CITY OF PORTLAND

Job ID: 2011-05-1200-CH OF USE

has permission to Change of use, office to Lodging House with 10 rooms, transient or non-transient 1-1st fl, 5-2nd fl, 4-3rd fl provided that the person or persons, firm or corporation accepting this permit shall comply with all of the provisions of the Statues of Maine and of the Ordinances of the City of Portland regulating the construction, maintenance and use of the buildings and structures, and of the application on file in the department.

From: "McCarthy, Richard" <RICHARD.M.MCCARTHY@maine.gov>
To: <wallaceb@portlandmaine.gov>
Date: 6/15/2011 2:43 PM
Subject: Re: 19 Bramhall St, Portland

19 BRAMHALL ST
(FIRST FLOOR)
FIRST FLOOR PLAN
SCALE 3/16" = 1'-0"

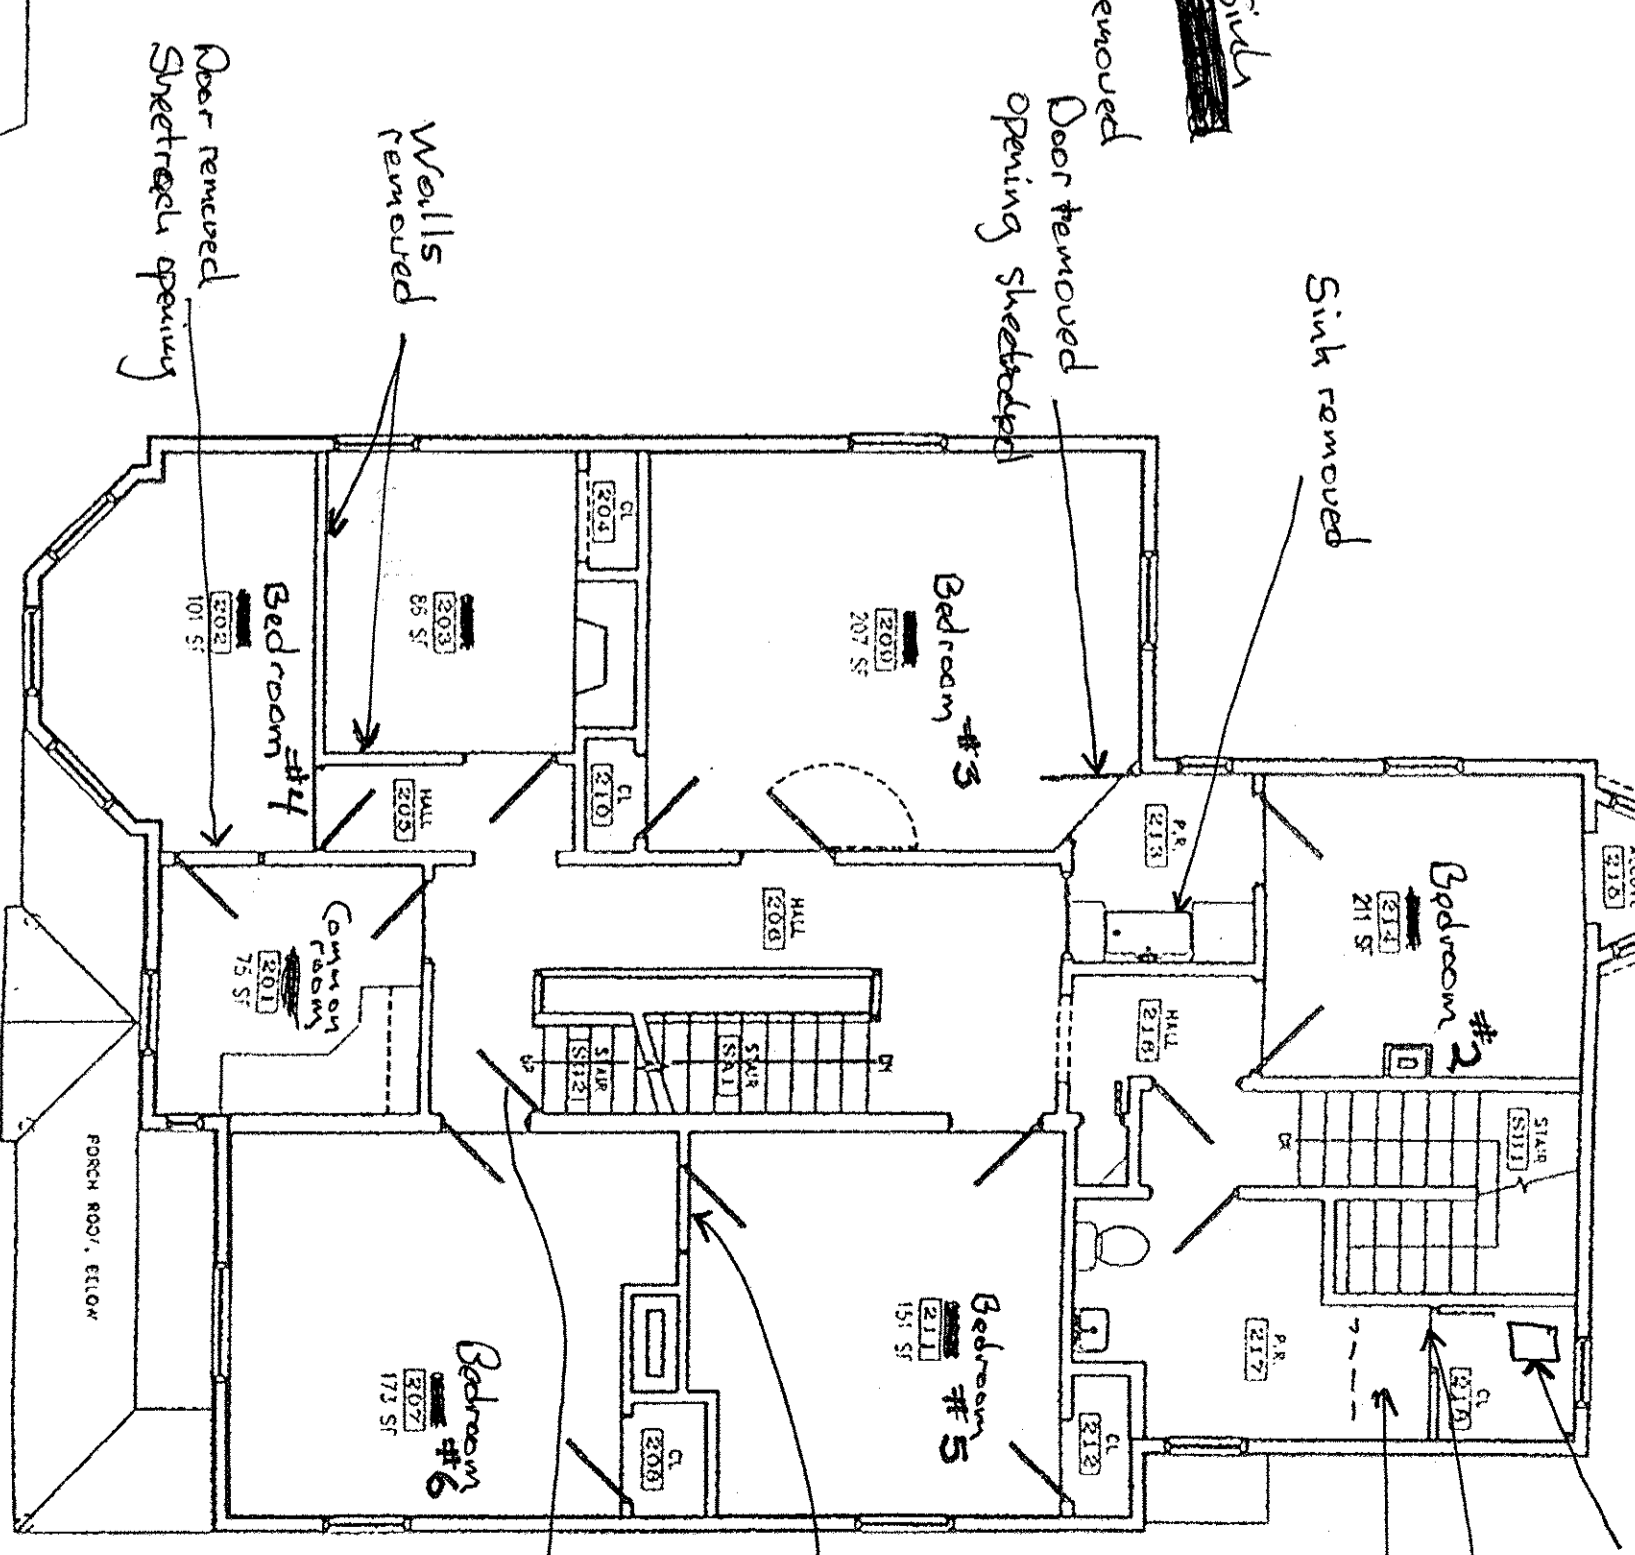
I was hoping to pick your brain about the conversion from business use to rooming and lodging house at 19 Bramhall St here in Portland. The building is being sprinklered 13D per LSC requirements and does/will have a supervised fire alarm system. There is 2 unseparated exit stairs from the 1st to 2nd floor, but only one from 2nd to 3rd.

19 BRAMHALL ST
(SECOND FLOOR)
SECOND FLOOR PLAN
SCALE 3/16" = 1'-0"

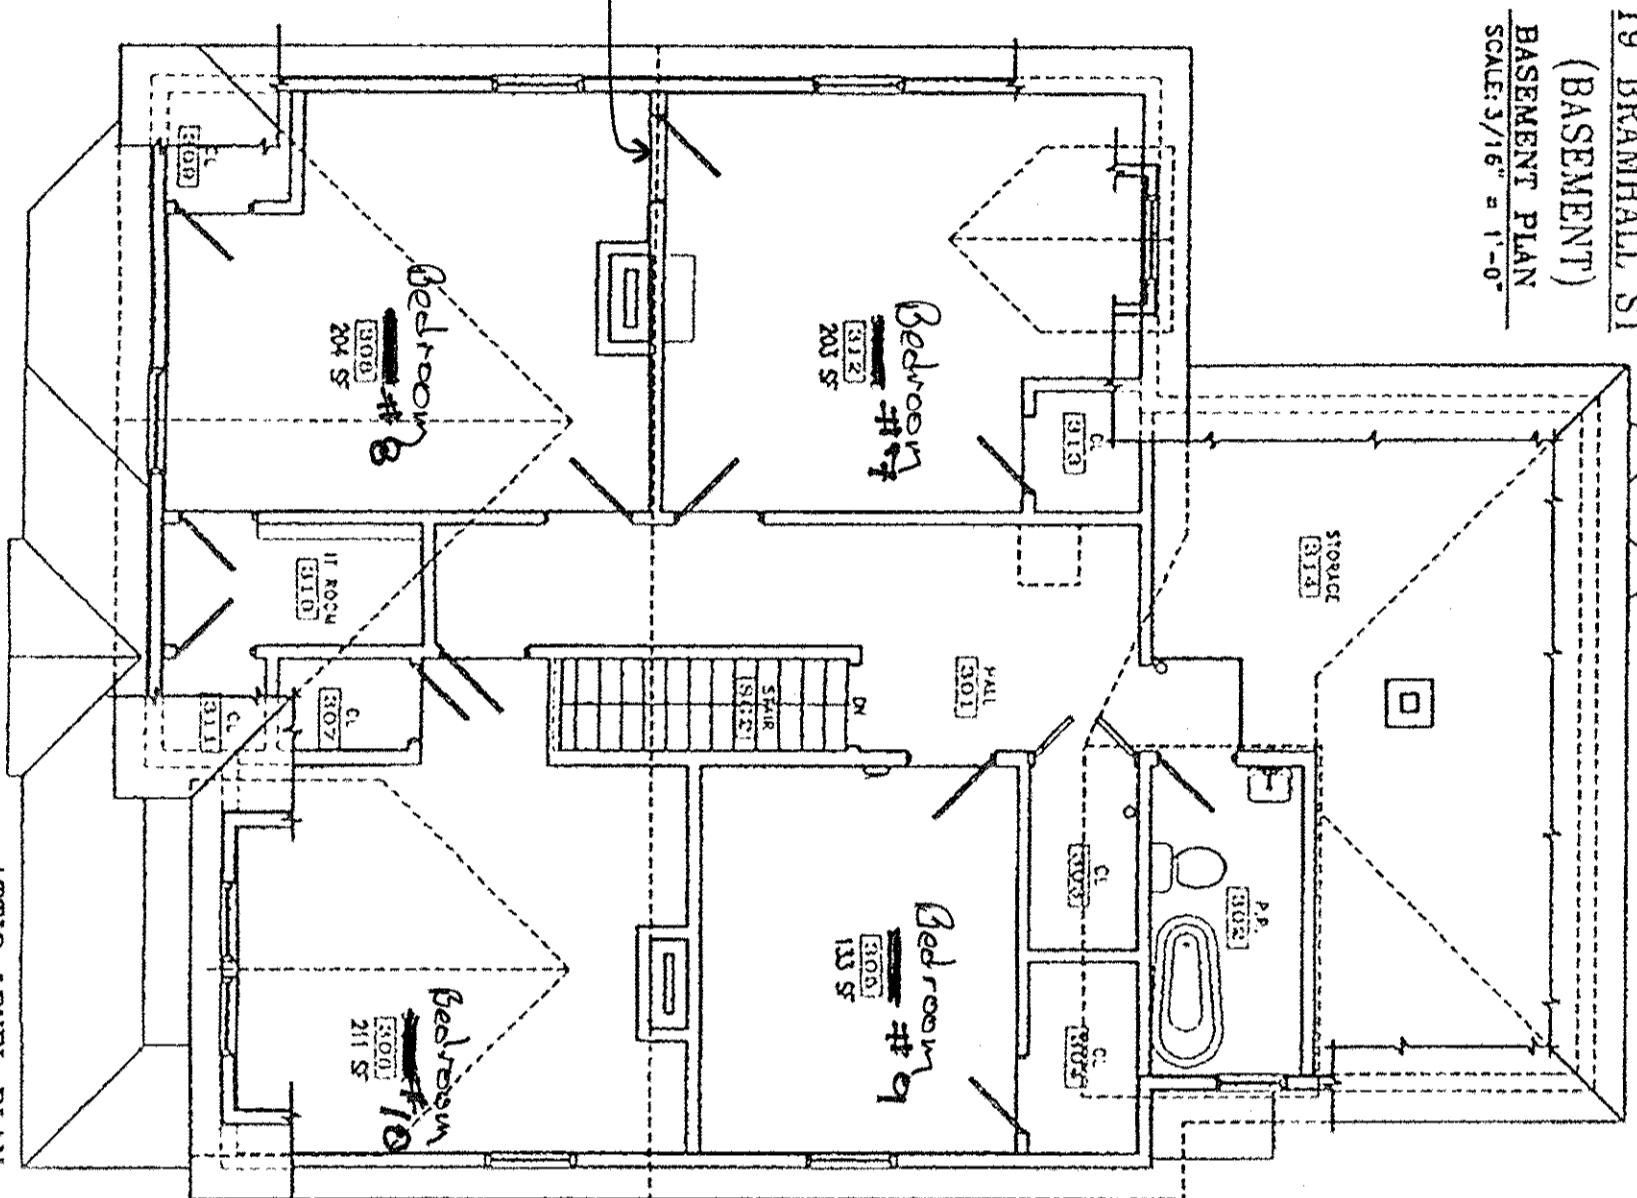
Q. Did you sign off on the two means of egress above the first floor required by MRSA 25 SS 2453 under the exception for apartment buildings 3 stories or less?

Q. Did you sign off on the unenclosed vertical openings not having a 1/2-hour rating? I don't see an exception to the enclosure in LSC.

First this building was reviewed under rooming and lodging so title 25 second 2453 does not apply and the code allows one exit.

Second I spoke to Capt Gatreau about an alternate means of compliance for the 1/2 hour separation. We came up with the sprinkler company placing additional heads near the doors, painting them with an intumescent paint I also spoke to Eric Ellis and he agreed with us.
